**STATE SIGNIFICANT DEVELOPMENT:
Section 96(1A) Modification Application**

AUSTRALIAN TECHNOLOGY PARK, EVELEIGH

SSD 7317 MOD 3

Environmental Assessment Report
Section 96(1A) of the *Environmental Planning
and Assessment Act 1979*

1 DA SIGNAGE ELEVATION - WEST
1 : 200

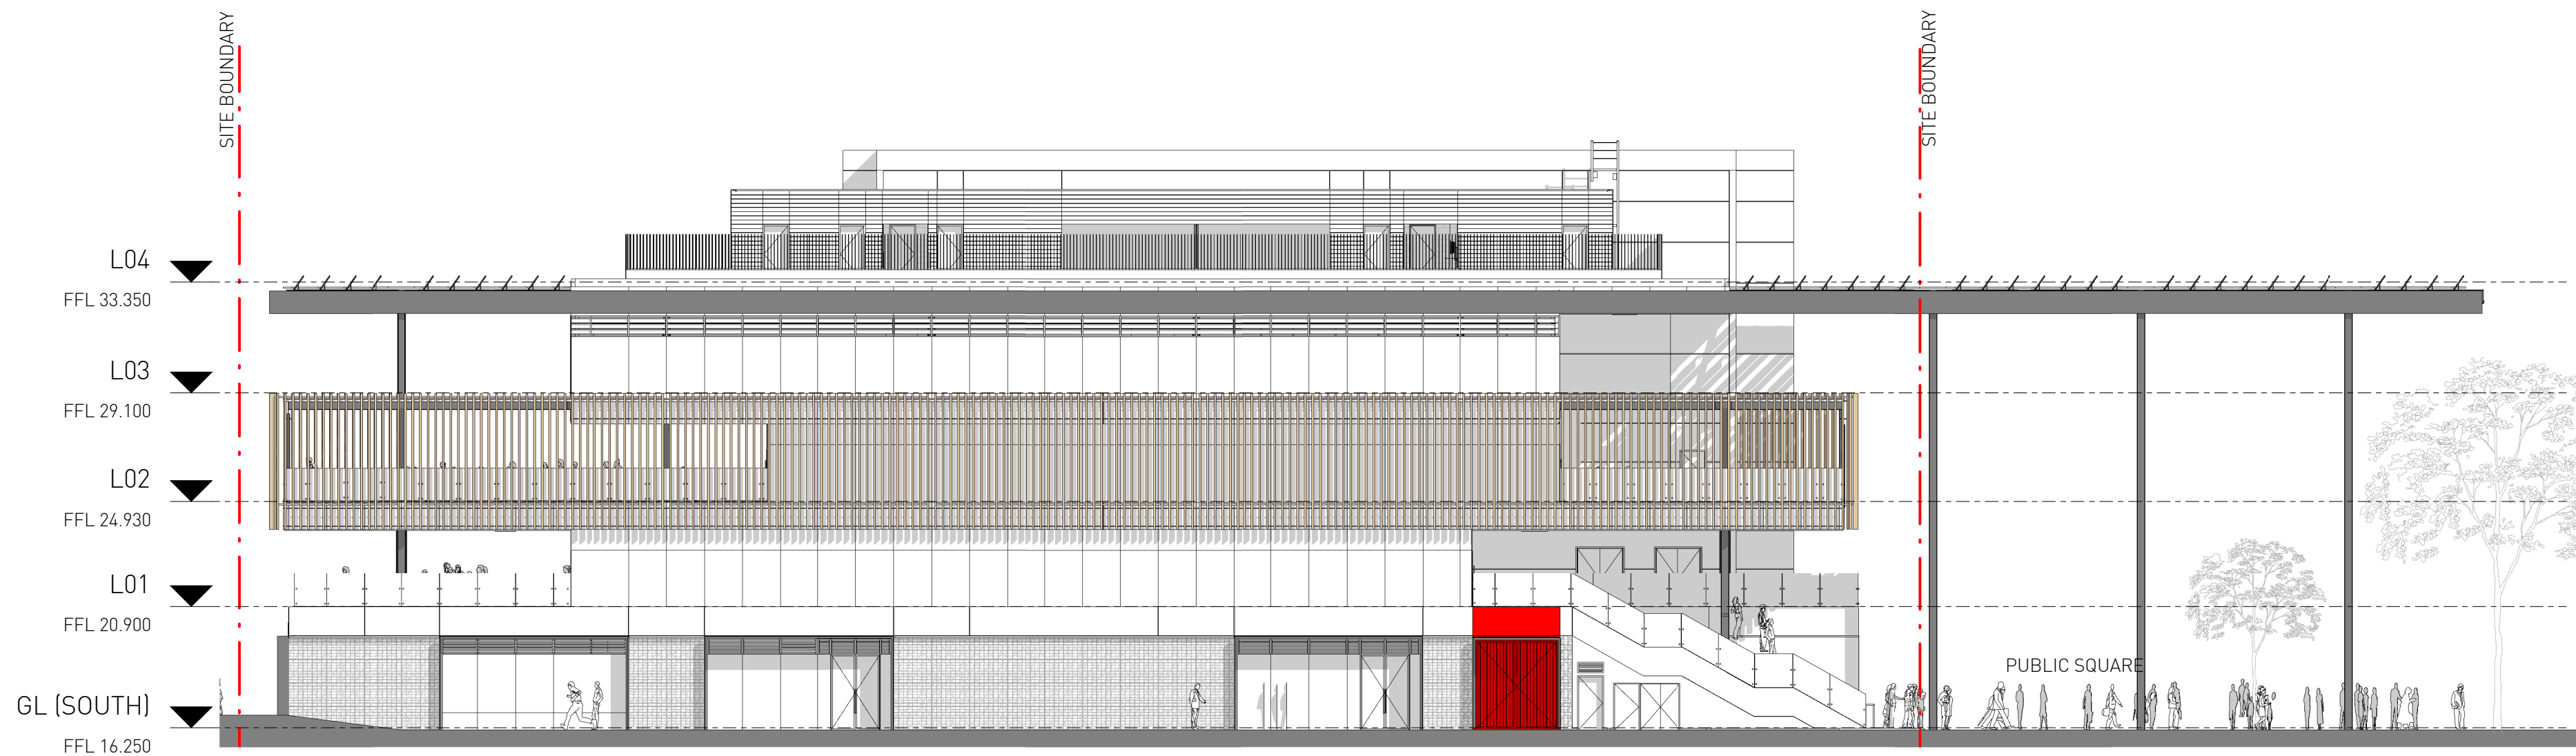
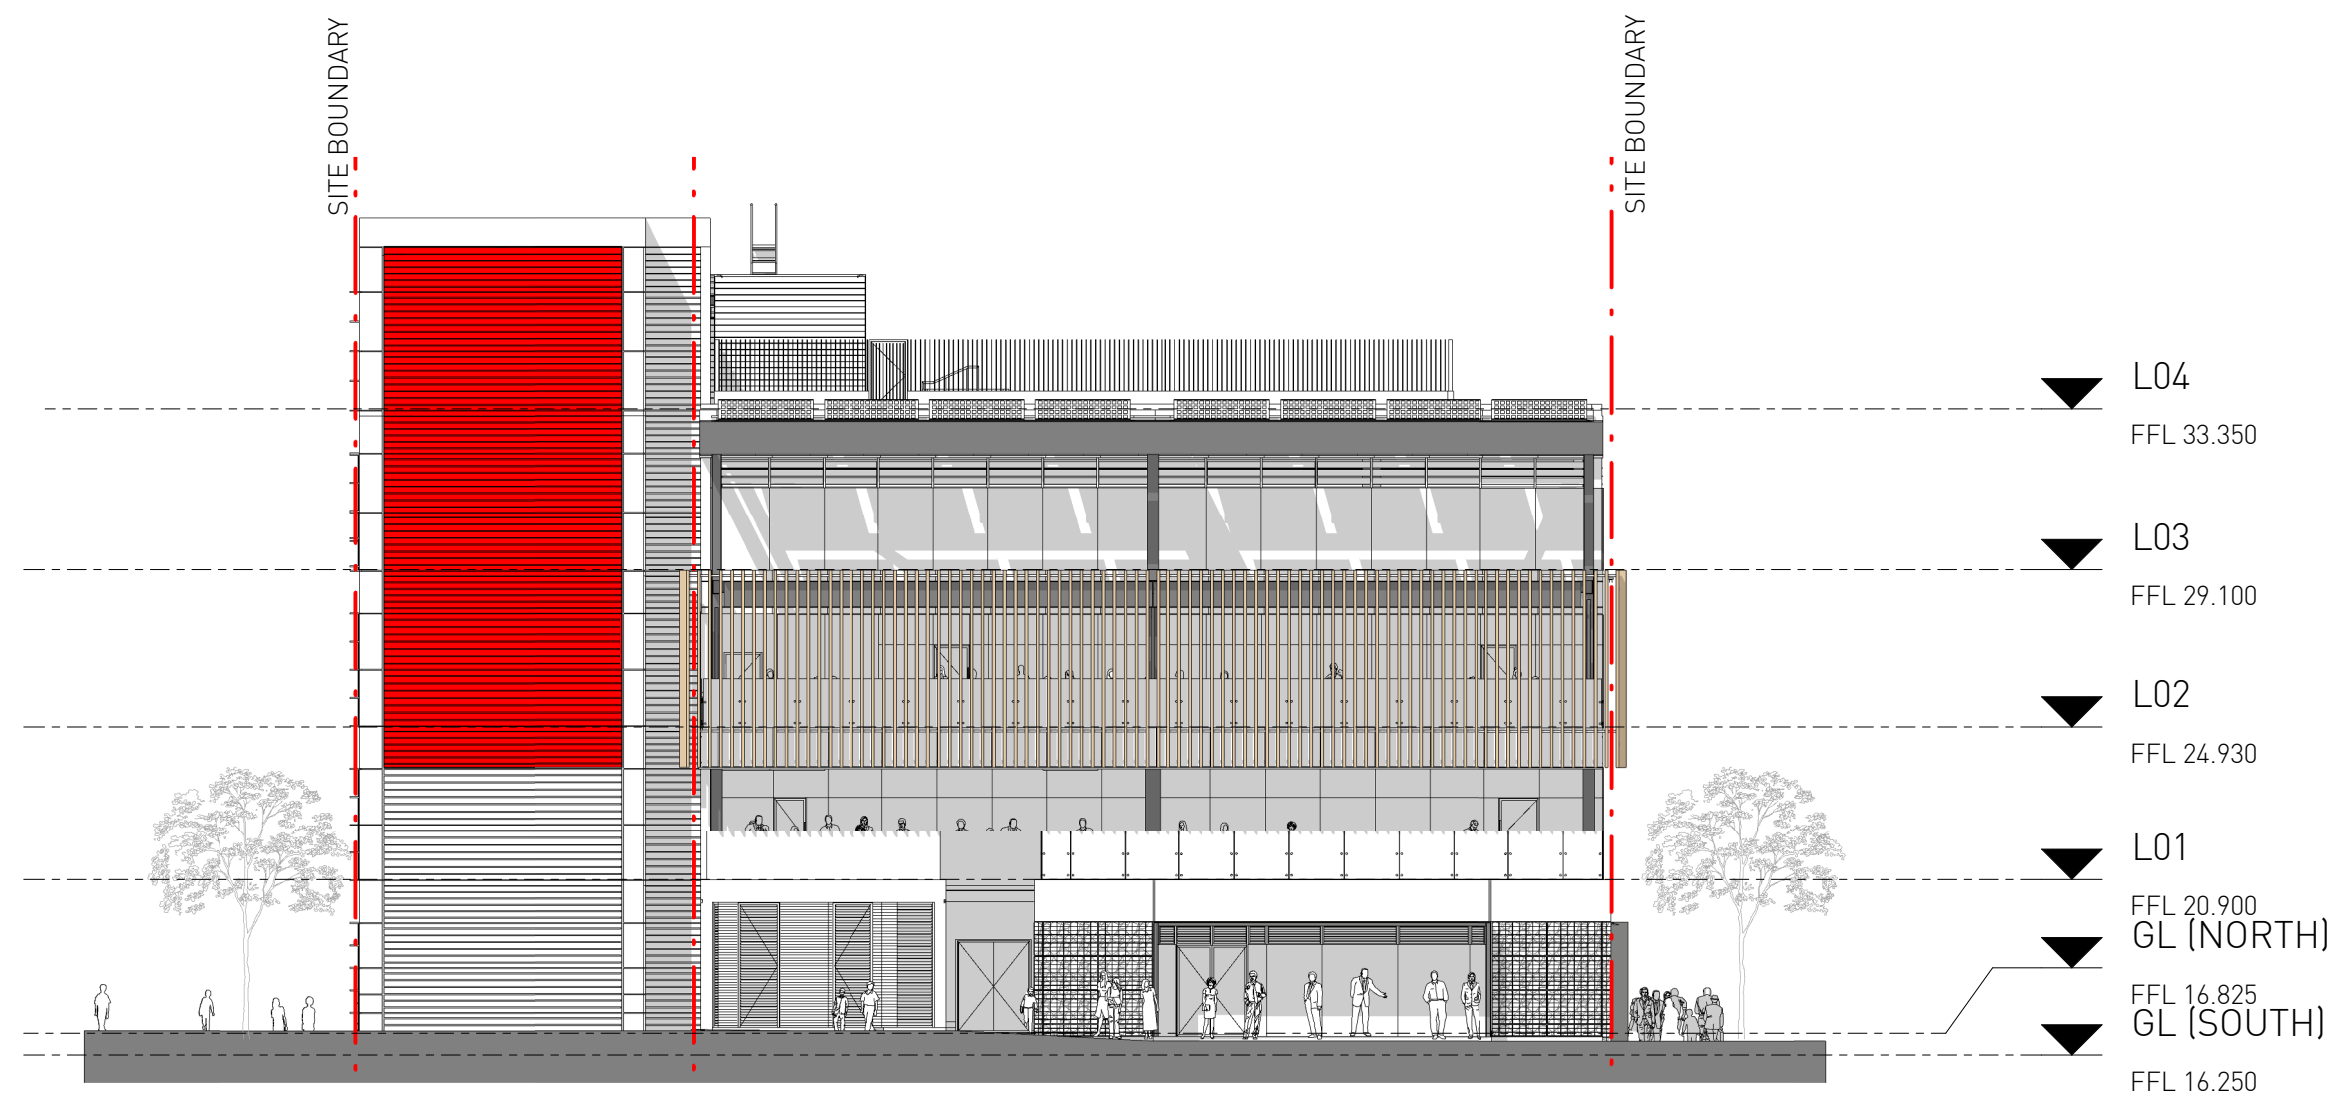
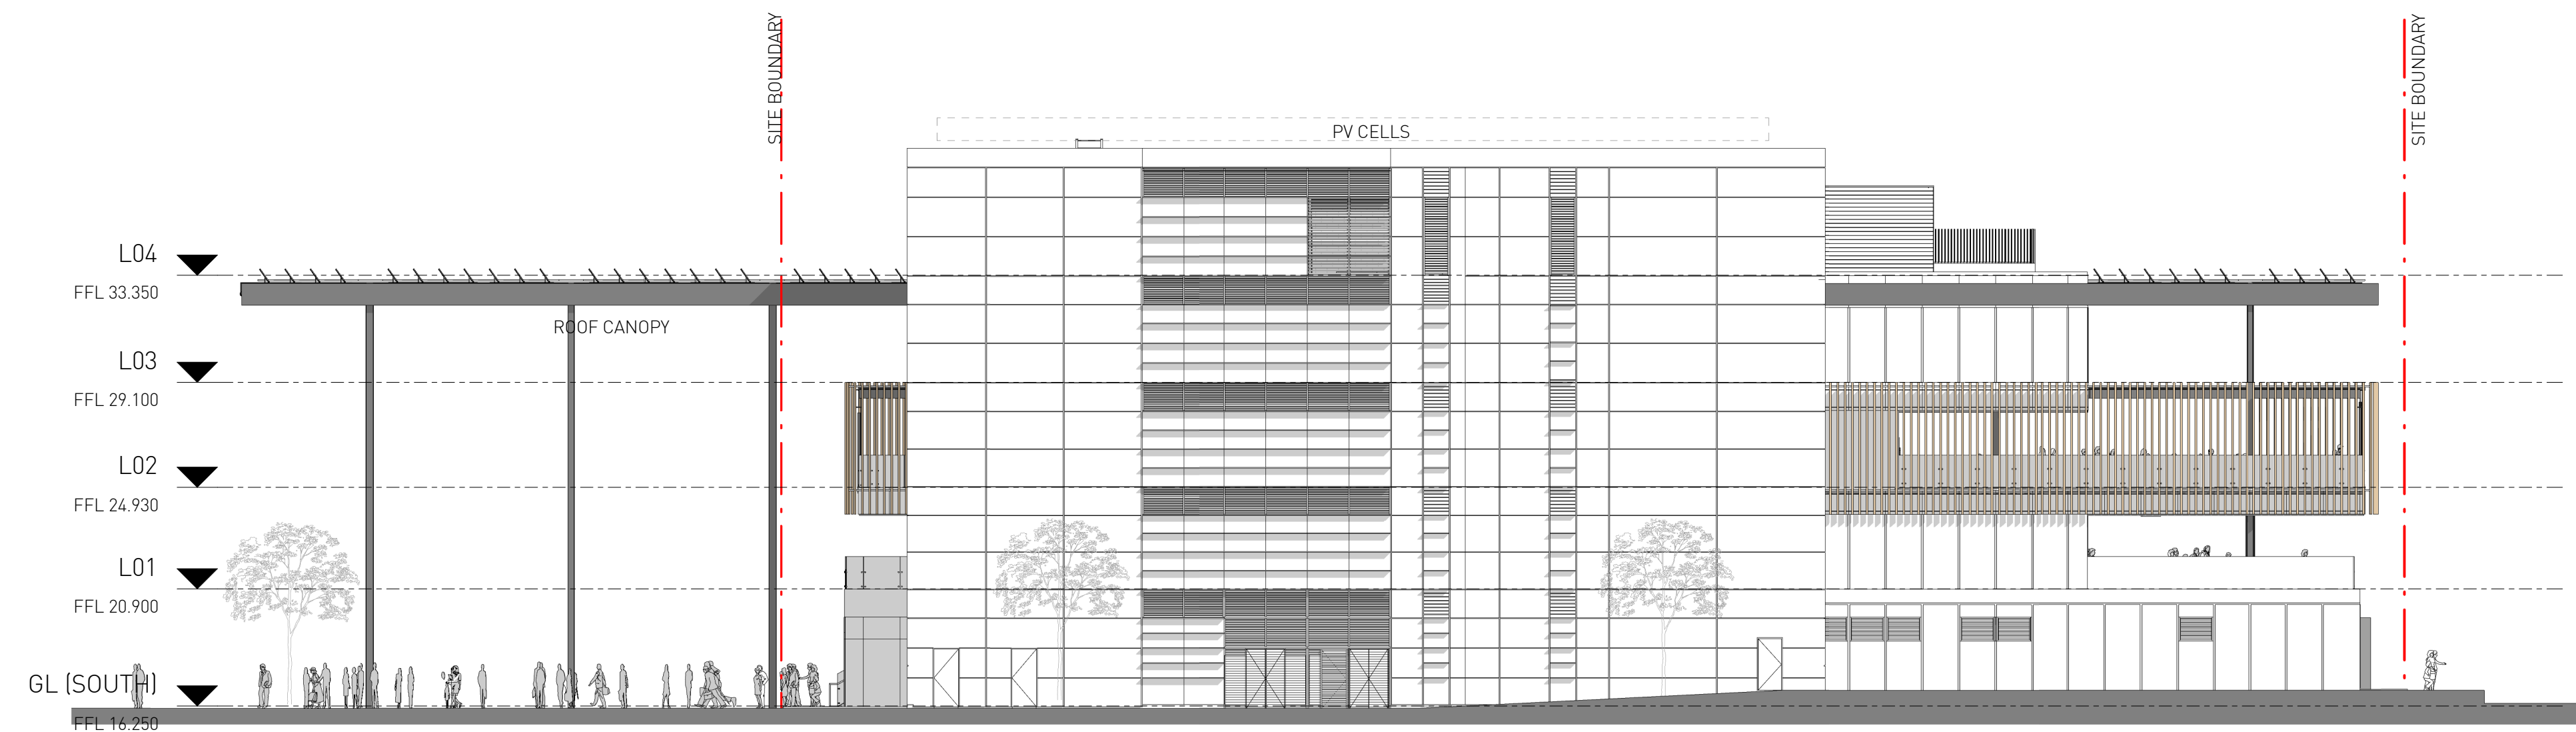
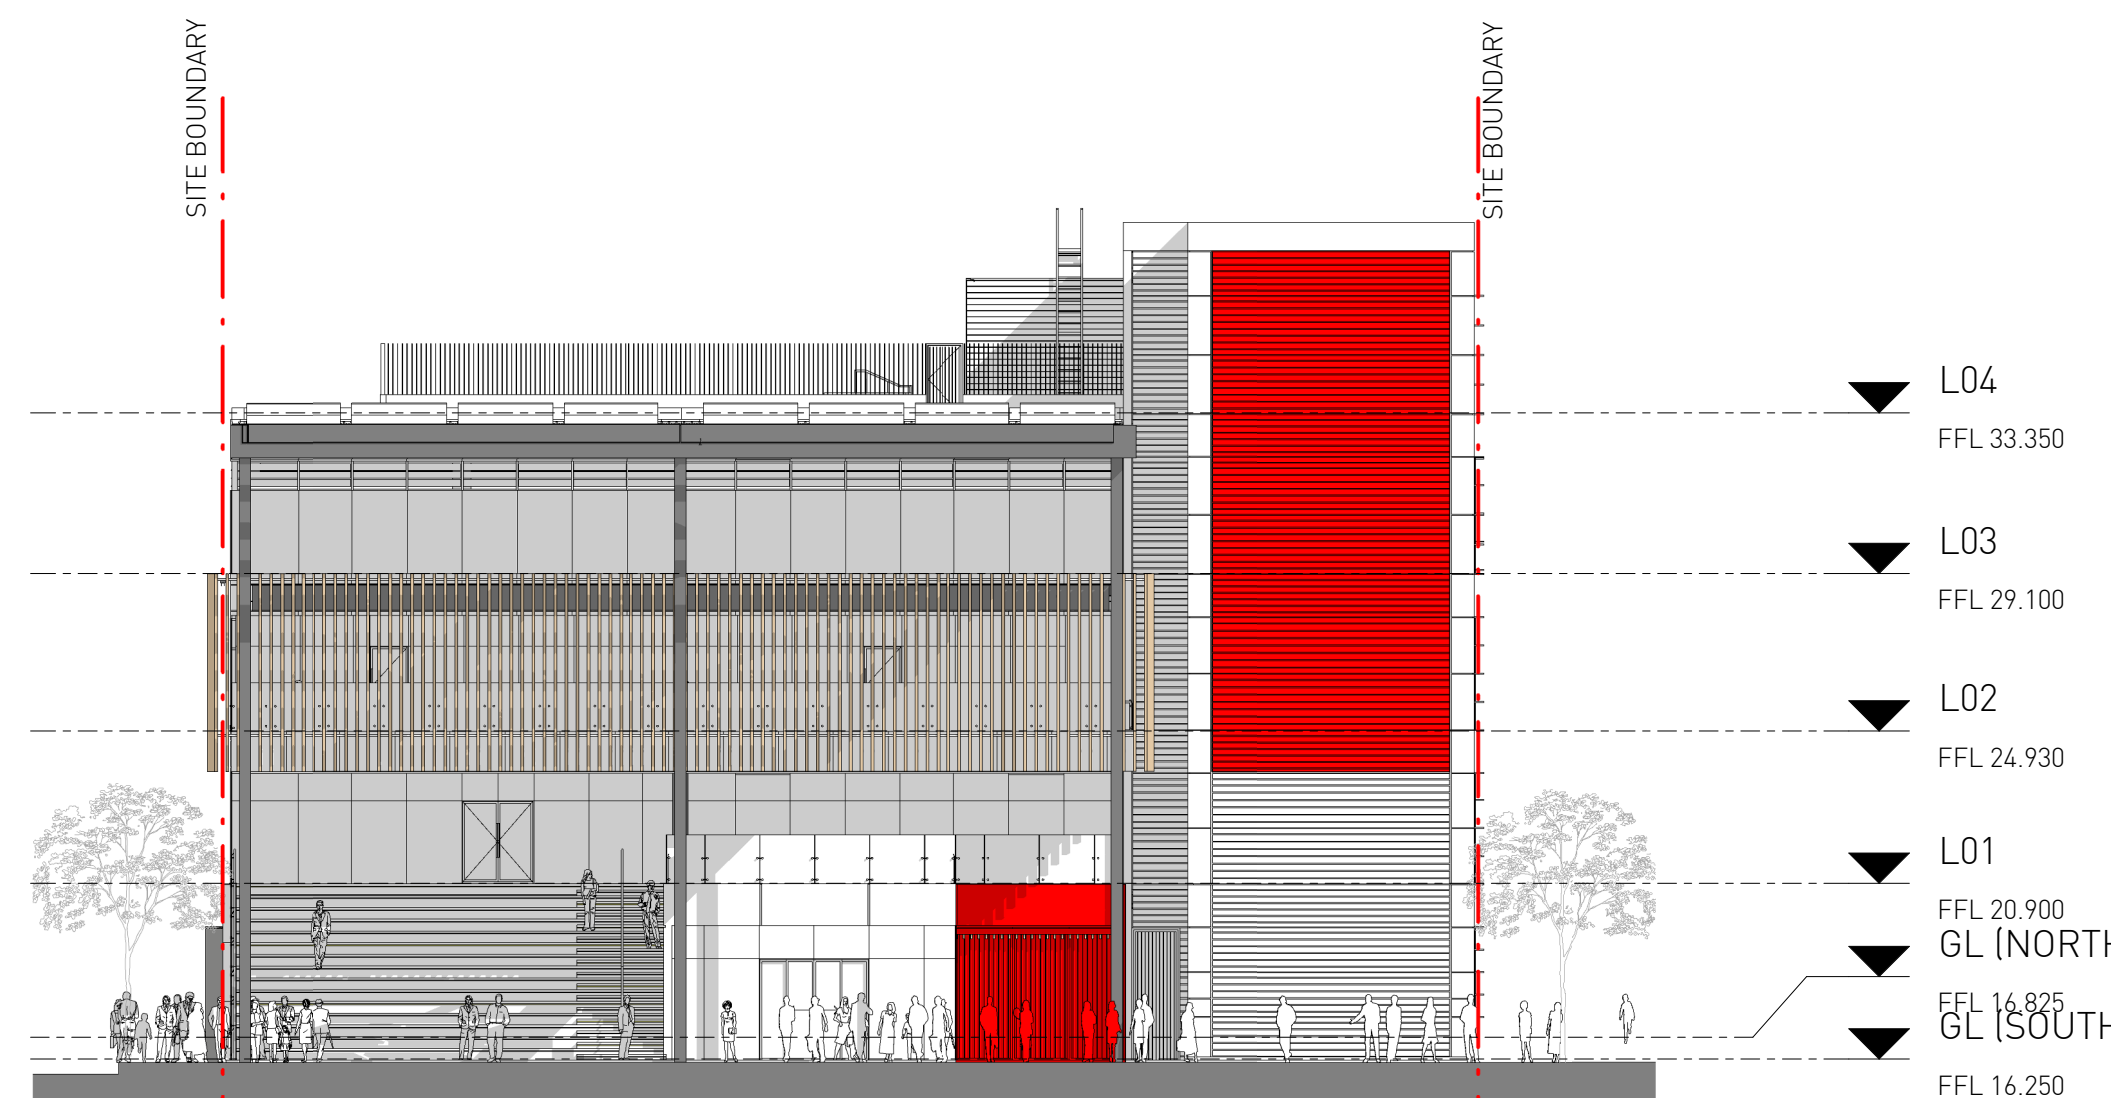
The application is proposing four new signage zones for building identification signage on Building 3. Two signage zones are associated with retail tenancies on the ground floor on the western and southern elevation. The other two are large scale signage zones located on the service core, on the northern and southern elevations. The signage zones are intended to indicate the potential location of signage only, and no approval is being sought for the signage content as part of the subject application.

Council is satisfied with the information provided on signage in the RtS and withdrew their initial concerns relating to scale and signage type.

The Department considers the signage zones are appropriate in scale and use, and are well integrated into the architectural design of the building. Building identification signage is consistent with the broader signage strategy for Australian Technology Park which includes 13 building identification signage zones across Building 1 and 2. Furthermore, building identification will assist the community with wayfinding, and the use and awareness of the building by the community is essential to its success. An assessment of the signage zones against SEPP 64 can be found in **Appendix B**.

The Department notes the final design, content and illumination of any signage will be subject to approval by the Secretary prior to installation as required by Condition F7 of the original consent by the Commission.
